Response to Submissions

State Significant Development Application (SSD 7917) Proposed Warehouse/Distribution and Industrial Facility

Lot 3, Horsley Drive Business Park (Lot 5 in DP 1212087)

Figure 1: Site Survey and Monitoring Position

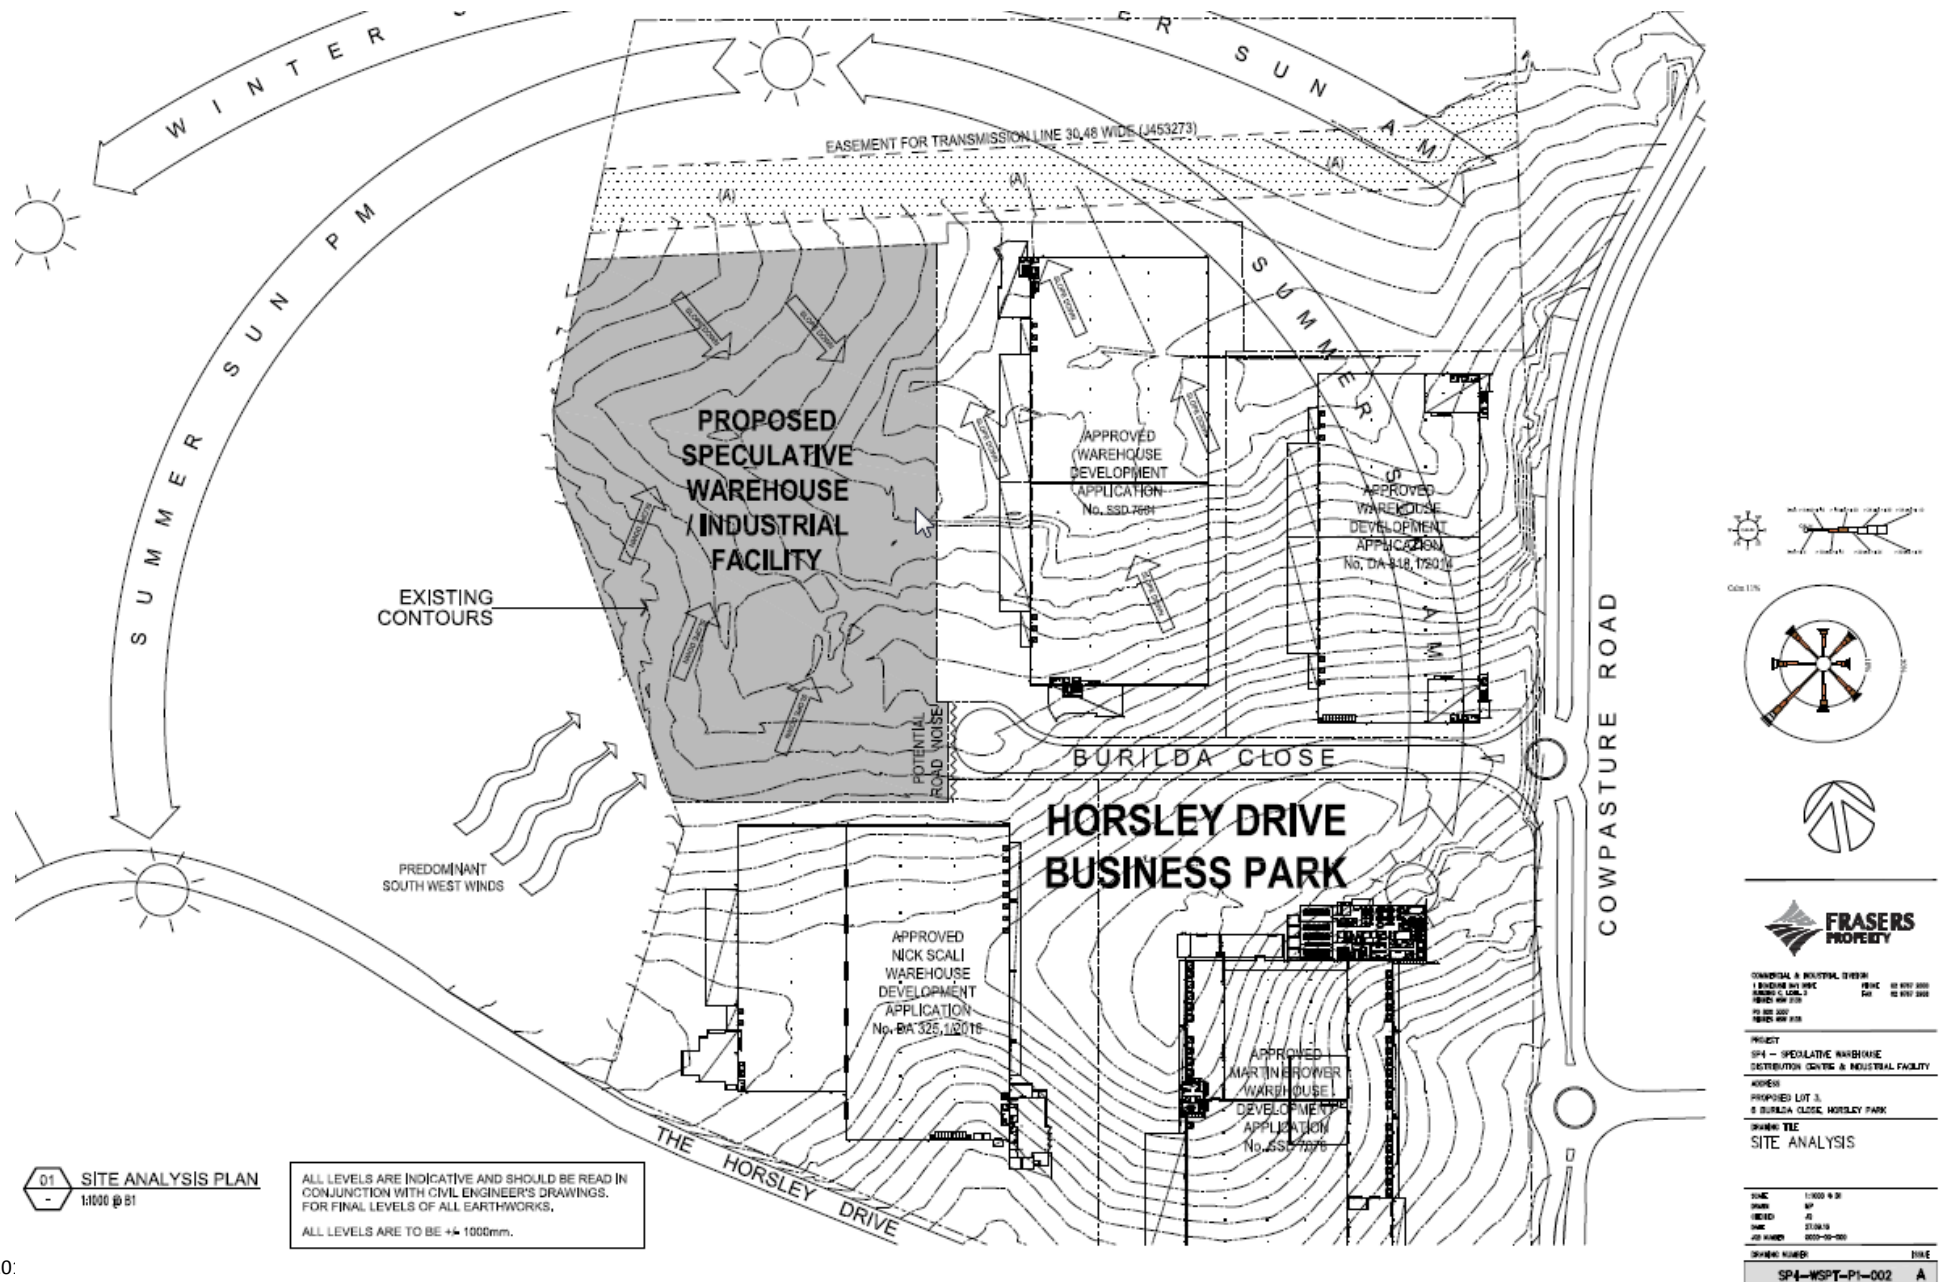
- 1489 The Horsley Drive, Horsley Park, please confirm the location of this site, the acoustic report states the site as 350m west of the site and Figure 1 does not show this;

- The acoustic report states there is a residential receiver located at a property south west that is 150m from the subject site. Please update Figure 1 in the acoustic report to demonstrate the location of this receiver;

- Figure 1 does not show a noise receiver at 2614 Cowpasture road, Horsley Park, please confirm the location of this; and
 - Ferriers Rd, Horsley park, please confirm the residential street number.

- Confirm the locations of the receivers for the "West residence" and "South West Residence" locations in Table 8 – Predicted Noise Levels.
- Ensure that the sensitive receivers identified in Tables 8 and 9 are identified in the same manner in Figure 1.

In relation to the noise receivers, Figure 1 within the Noise Impact Assessment has been updated to show 1489 The Horsley Drive located 350m west of the site.

The residential property to the south-west has been shown in Figure 1 which demonstrates that it is 150m from the site. Similarly, the noise receiver at 2614 is now shown also within Figure 1.

All relevant Ferrer's Road residential properties are now shown in Figure 1. The location of the sensitive receivers for the "west residence" and south west residence" are noted under Table 8 within the Noise Impact Assessment and shown in Figure 1.

DRAWING NUMBER **SP4-WSPT-DA-110** ISSUE **B**

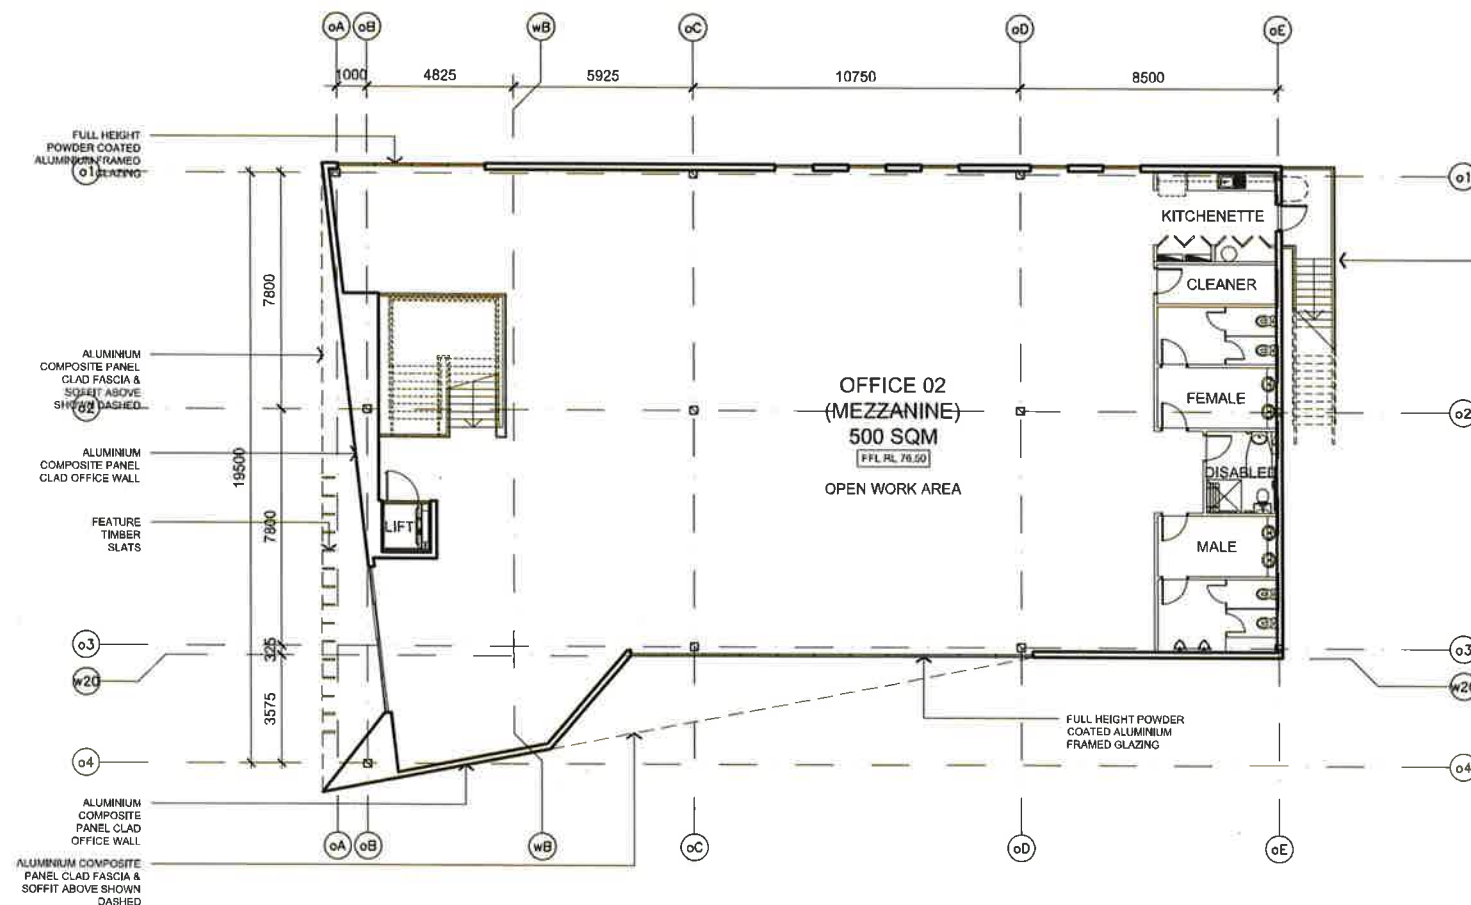
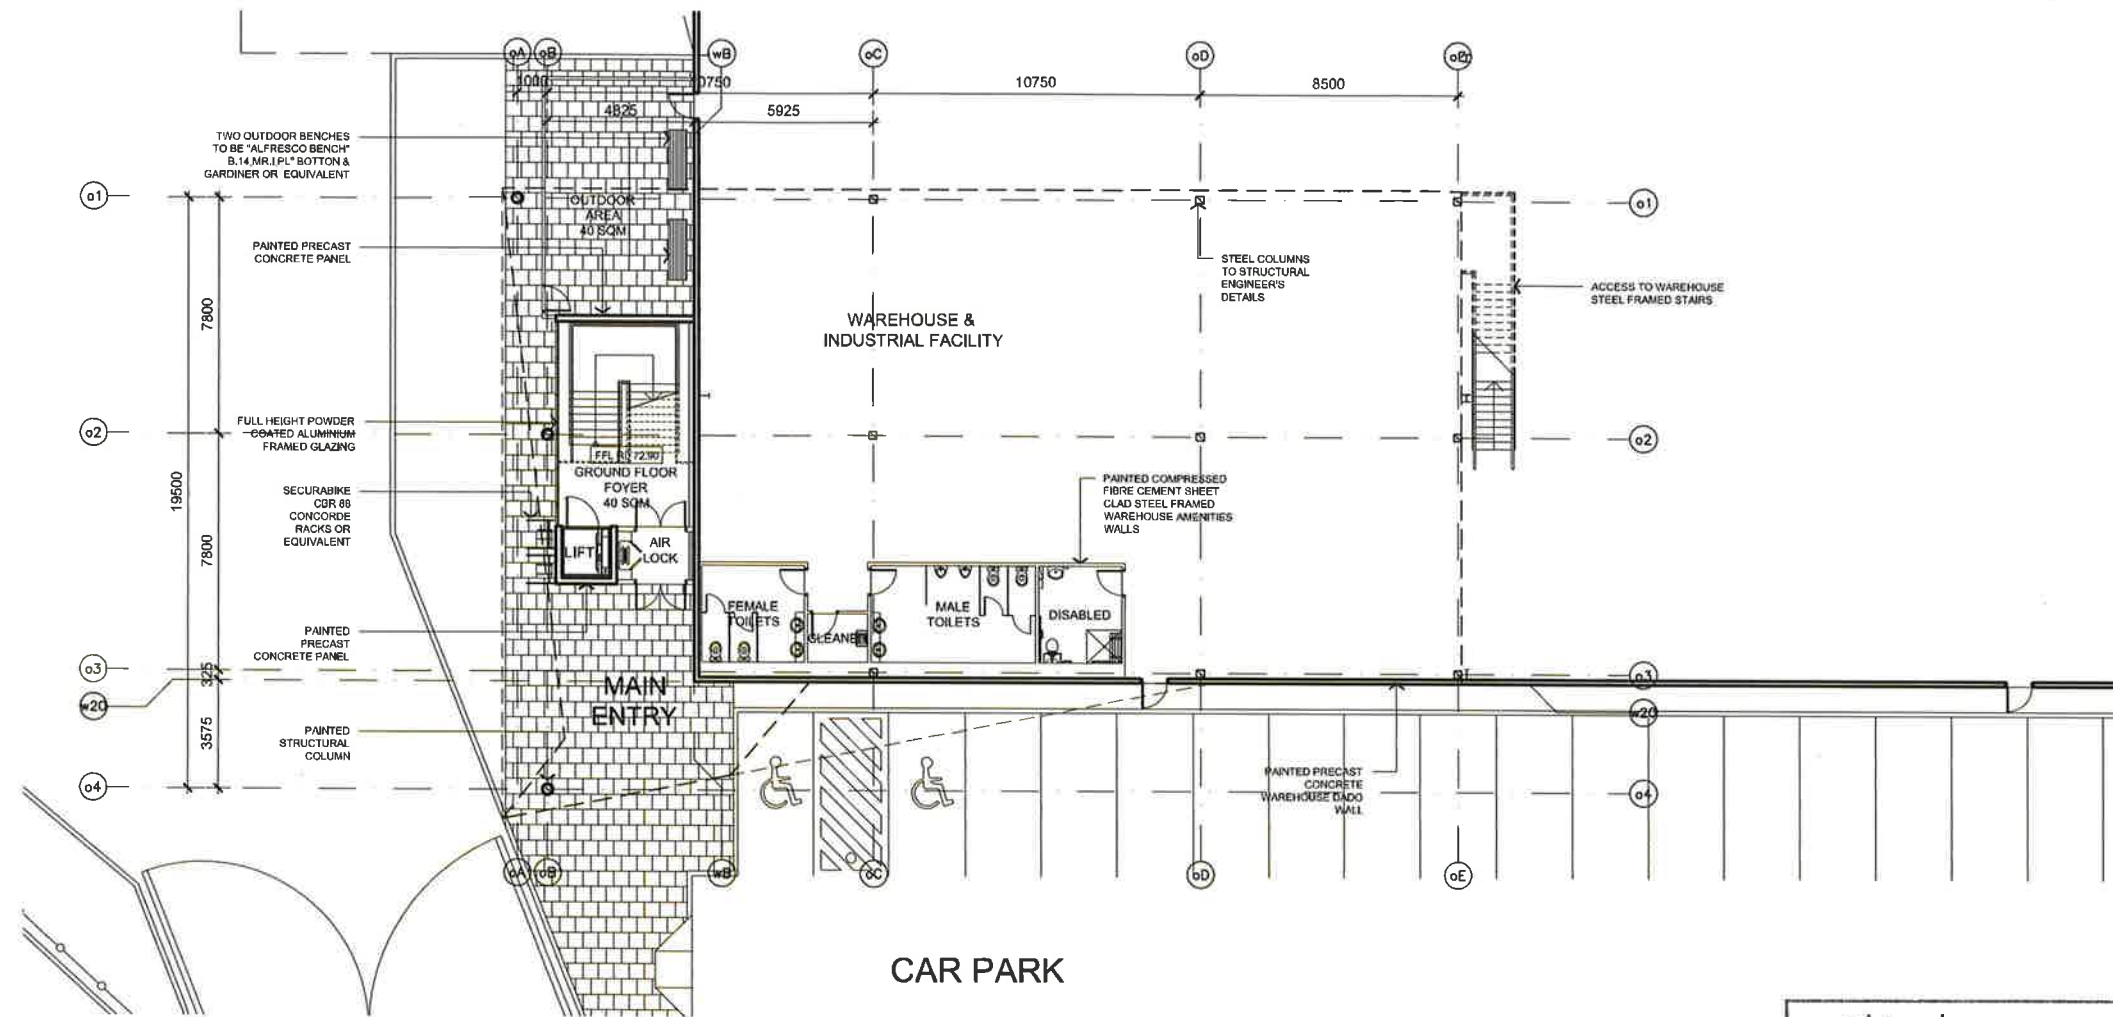
<p>d) Other items</p> <ul style="list-style-type: none"> ▪ The title of plan SP4-WSPT DA-110 is "Office 2" however, the actual plan refers to "Office 1", please clarify the name of this plan. ▪ Confirm the building height, as the EIS states 12.2m however, the Air Quality report has the proposed building height as 13.7m. 	<p>Revised Drawing SP4-WSPT DA-110 has been attached which relates to "Office 01".</p> <p>The proposed building height is 12.2m, as shown on the architectural plans. Reference to the height of the proposed warehouse as noted in the Air Quality report is to be disregarded for this application (Appendix 5).</p>
